Date 25 April 2022

RE: 6/2021/3422/MAJ - Salisbury Square, Hatfield, AL9 5AD

LLFA position

CLIENT: GASCZYNE ESTATES  
 JOB: SALISBURY SQUARE HATFIELD AL9 5AD  
 DRAWING TITLE: PROPOSED SITE PLAN GROUND FLOOR LEVEL  
 SCALE: 1:250 @ A1 / 1:500 @ A3  
 DATE: NOV 2021  
 STATUS: PLANNING  
 DRAWING NUMBER: 789 - PL - 109 C  
 REV: C  
 ISSUED BY: SR

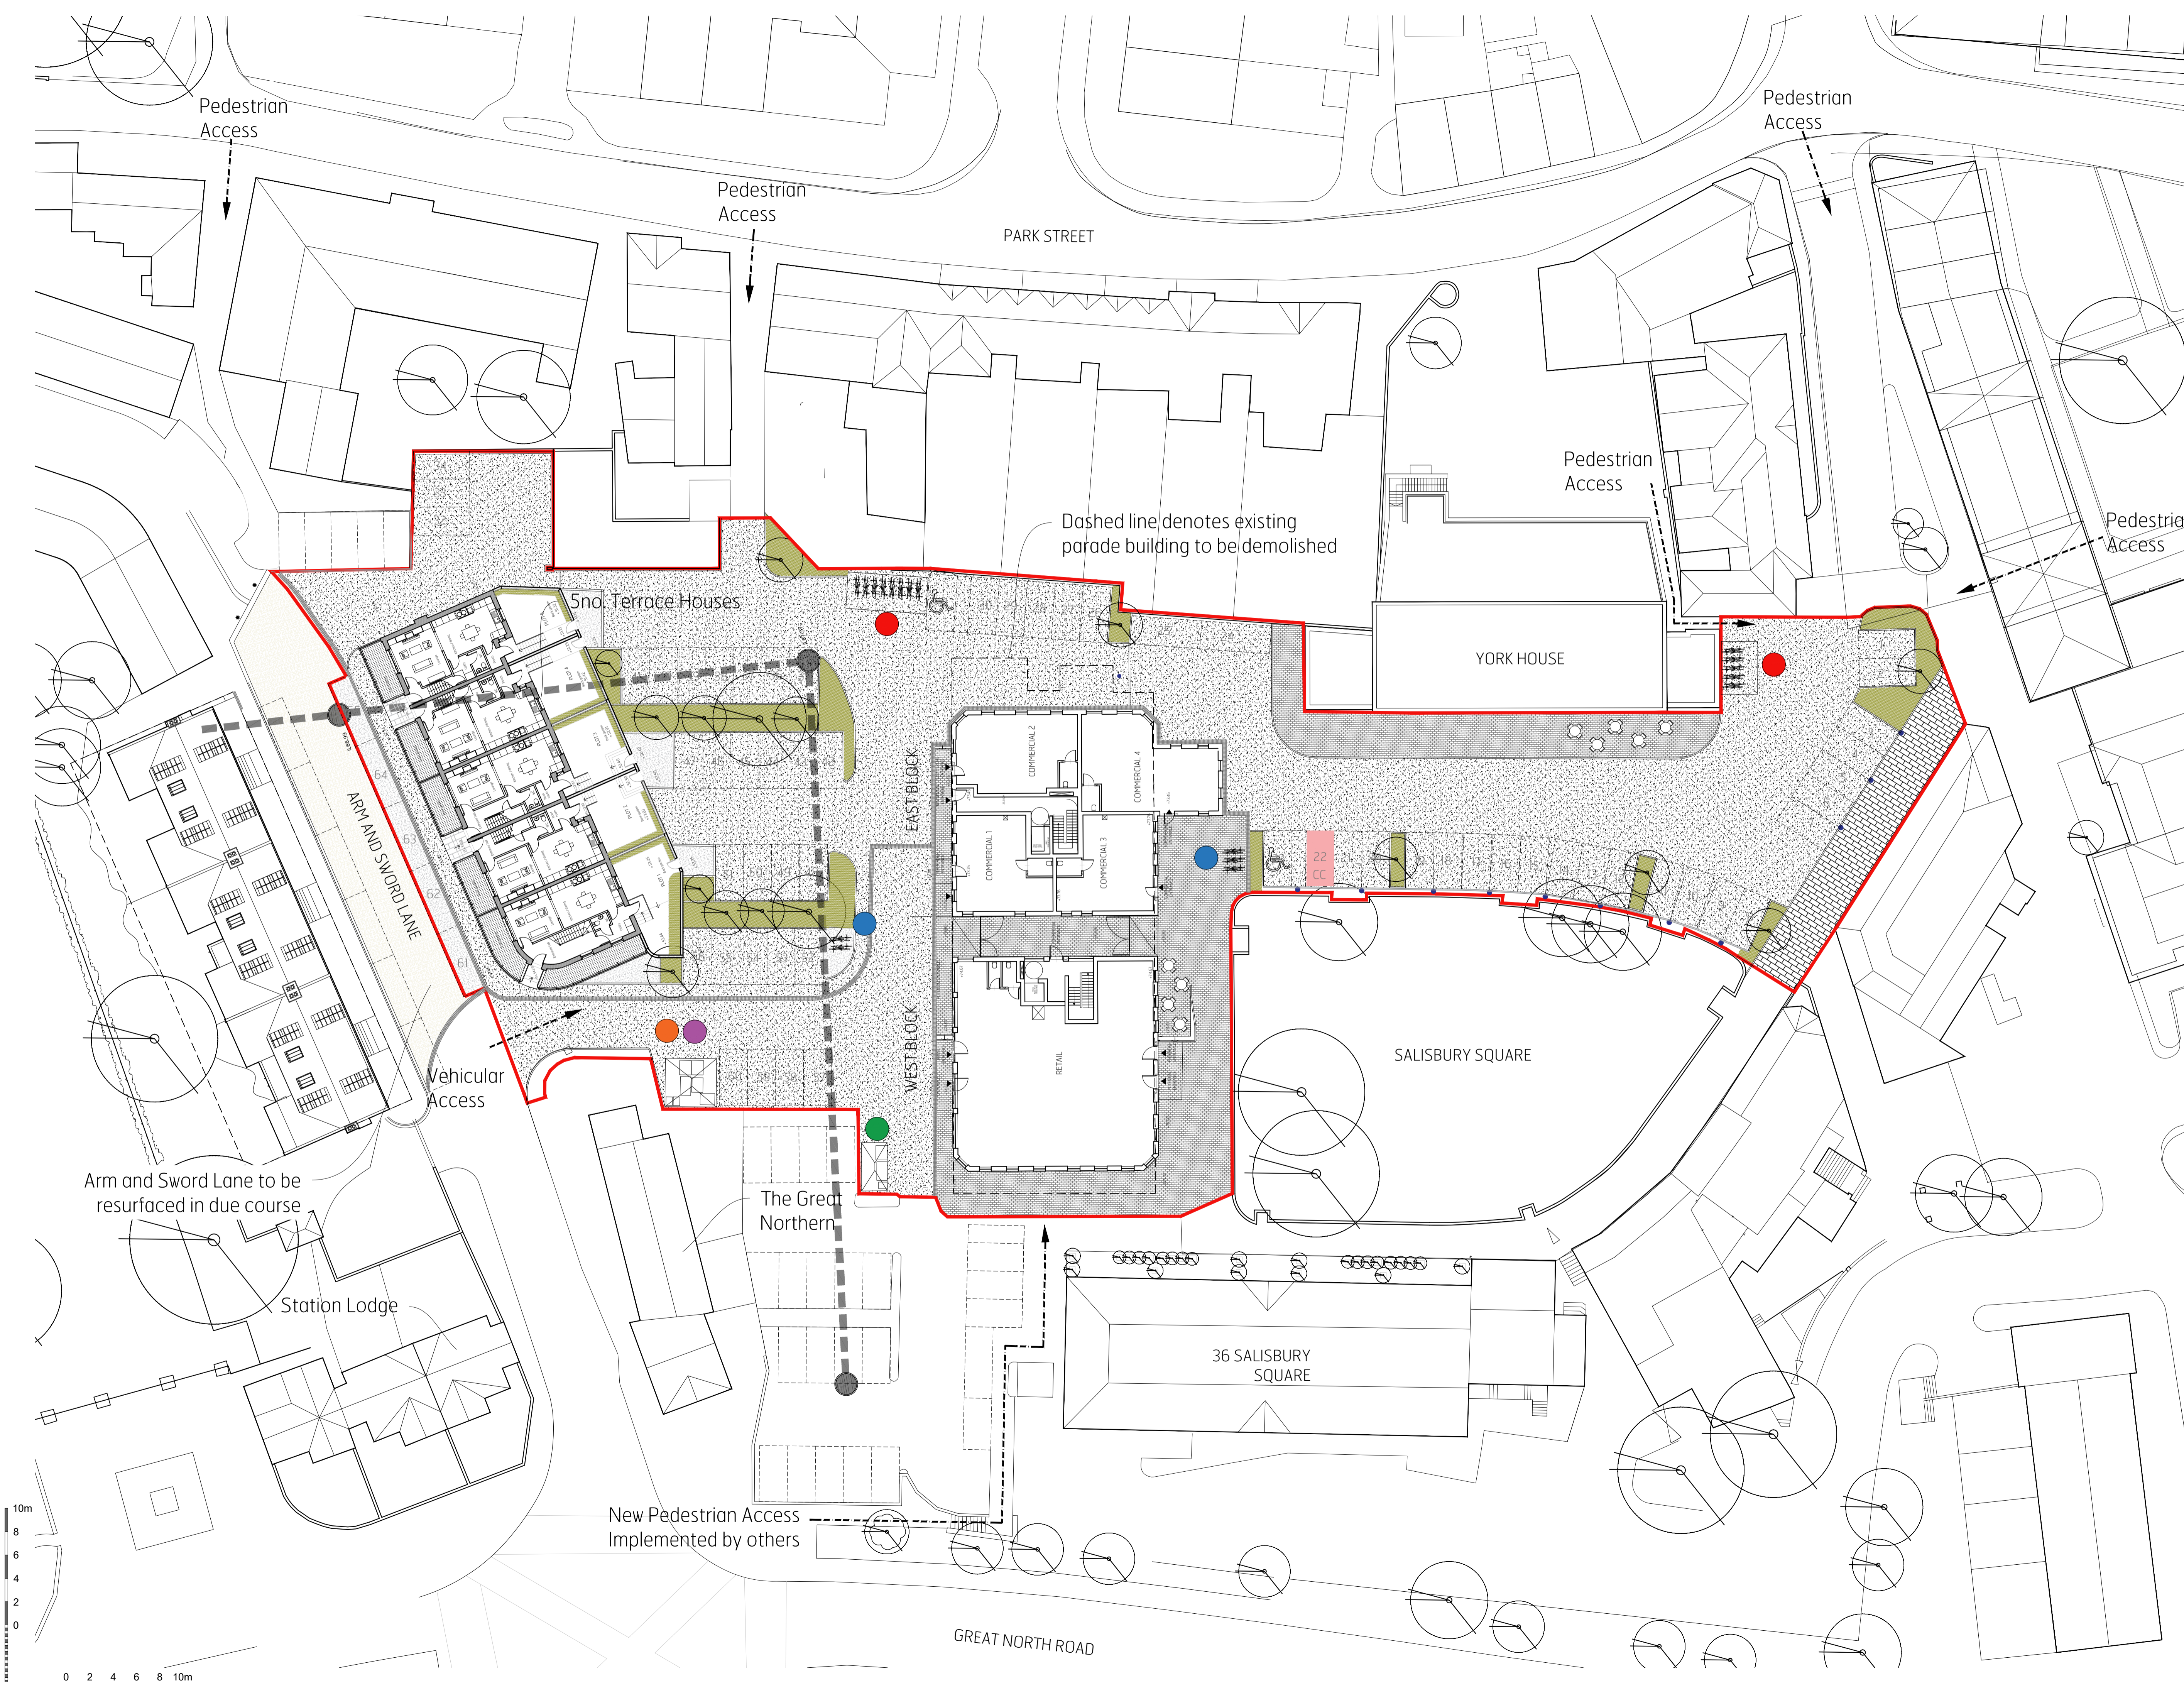
We require further clarification on the current method of discharge from the car park at the north of the site which is proposed to drain as per existing arrangement.
